CITY OF ALBUQUERQUE

November 17, 2023

Re: SAFStor Storage
Not addressed- SW corner of Central Ave and 106th St
UPC 100805638540210405
Request for Certificate of Occupancy- 30 Day Temp
Transportation Development Final Inspection
Engineer's Stamp dated 1-13-22 (L08-D013)
Certification dated 11-16-23

SAFStor STORAGE
ALBUQUERQUE, N.M.

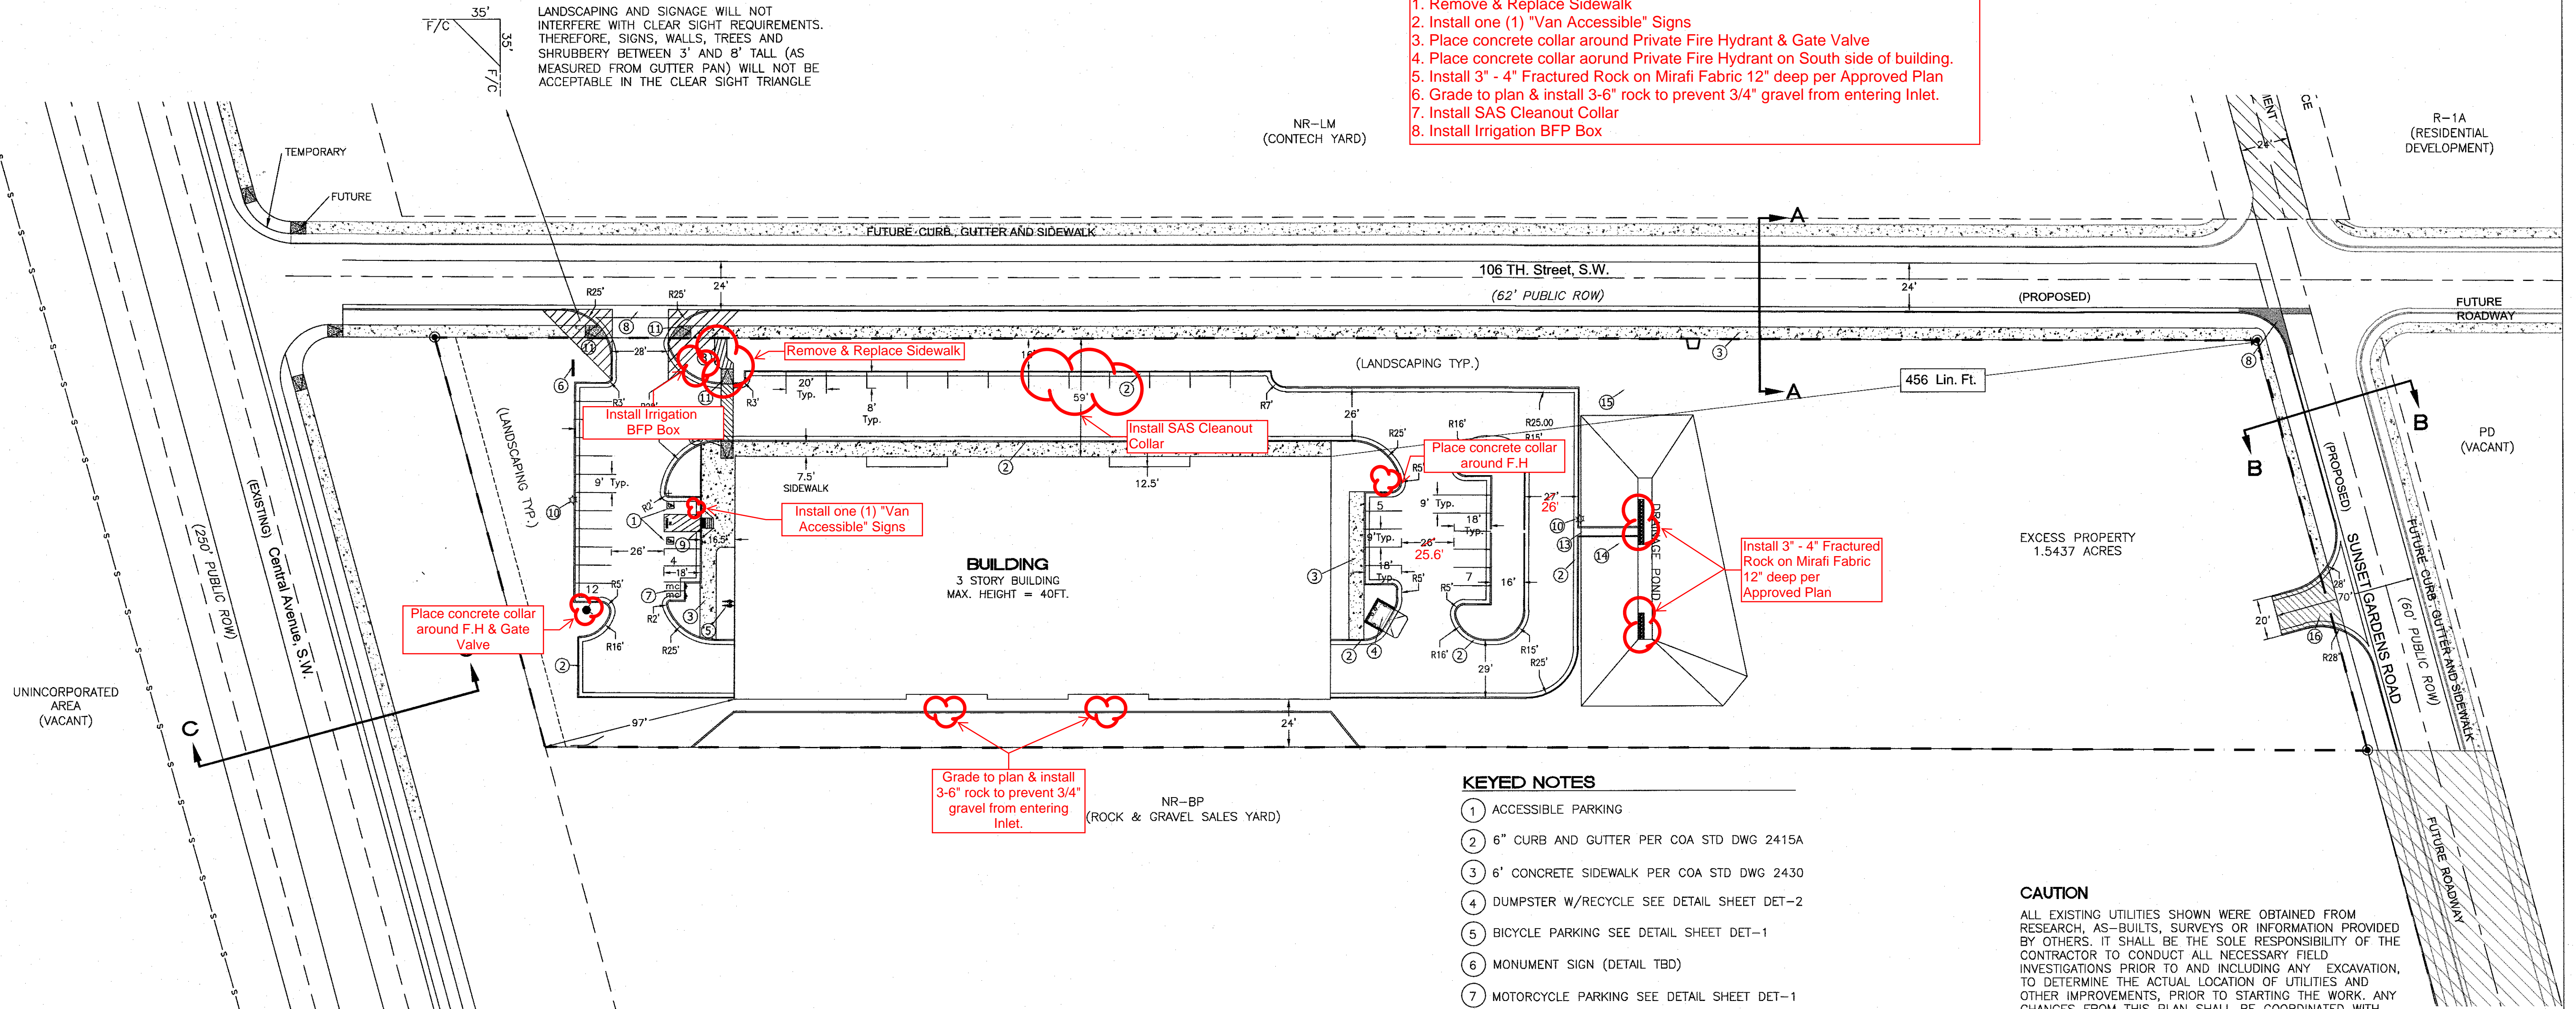
1. Access from an open (constructed and not barricaded) public street that can be used by motorists, pedestrians and cyclists is to be provided.
2. Complete the Transportation related items on the provided punchlist.
3. The handicap van aisle striping was only 5' wide, whereas, it is to be 8' wide.
